Our ref: 15155/AIA/Add/01

16<sup>th</sup> March 2022

**Re: Addendum to Arboricultural Impact Assessment ref: 15155**

I write with regard to the updated landscaping proposals at Williamson House, 4 Innage Close, Leamington Spa CV31 1BL as shown on Nicholas Dexter Ltd drawing 0290-1000-A. I understand from this plan that the landscaping scheme requires the removal of the category C apple T6 and the category C plum T7.

0290 - 3005 - A

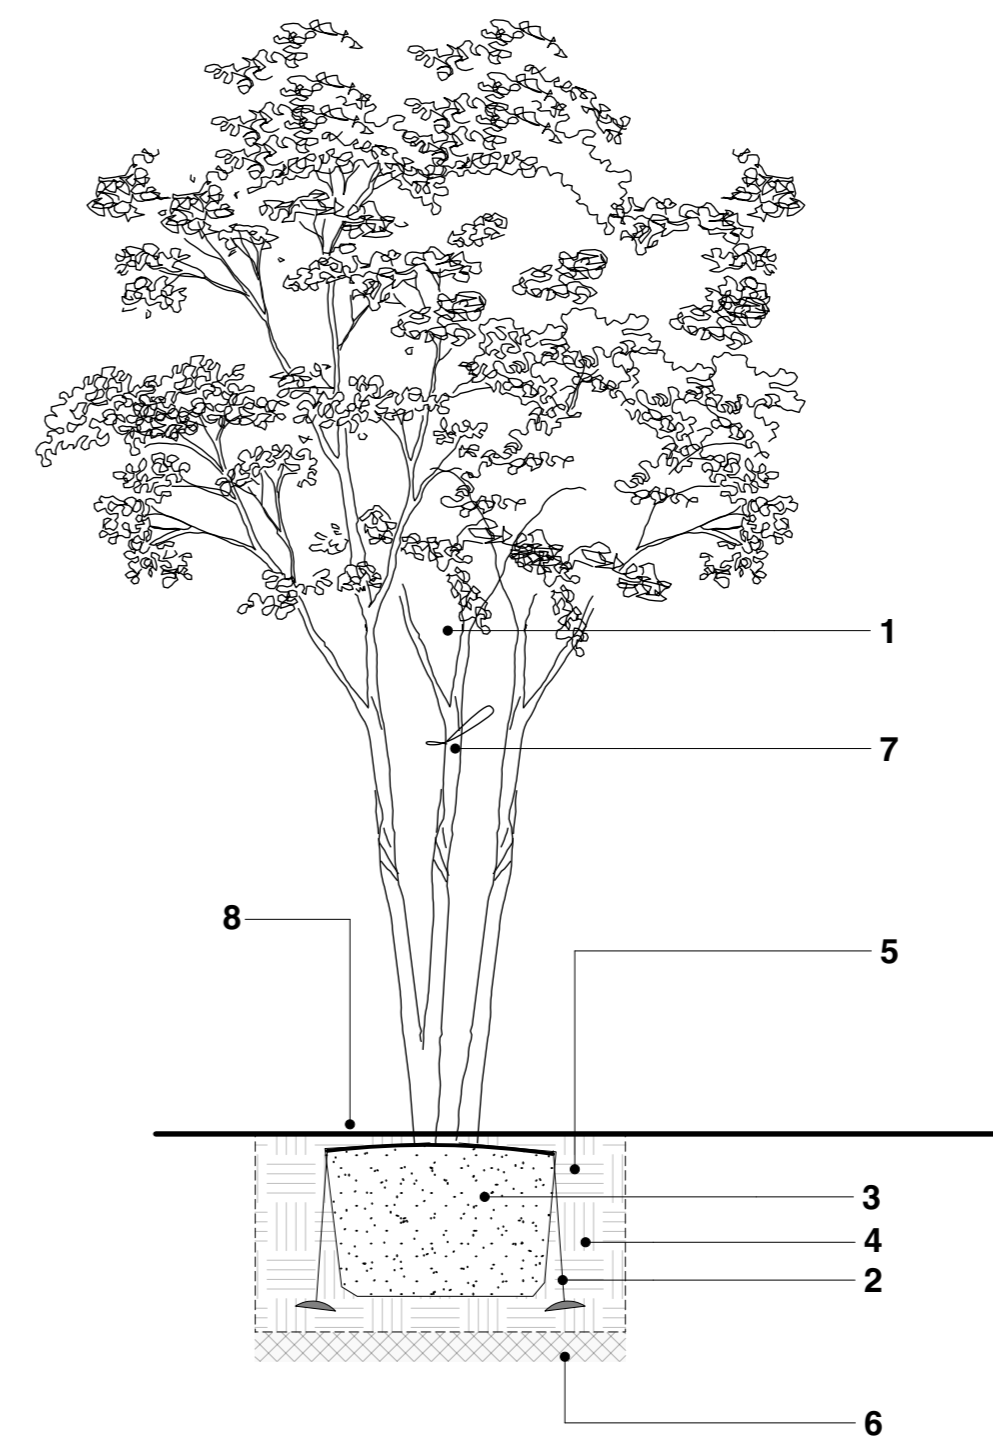
I would assess the loss of these trees as being of low impact to both the site and wider area and would comment that their removal will be amply mitigated by the proposed replacement tree planting as detailed on Nicholas Dexter Ltd drawing 0290-3005-A. I am aware that this replacement planting scheme does not replace trees on a like for like numerical basis but am confident that the quality of the tree cover present will be increased as will the life expectancy of the tree stock.
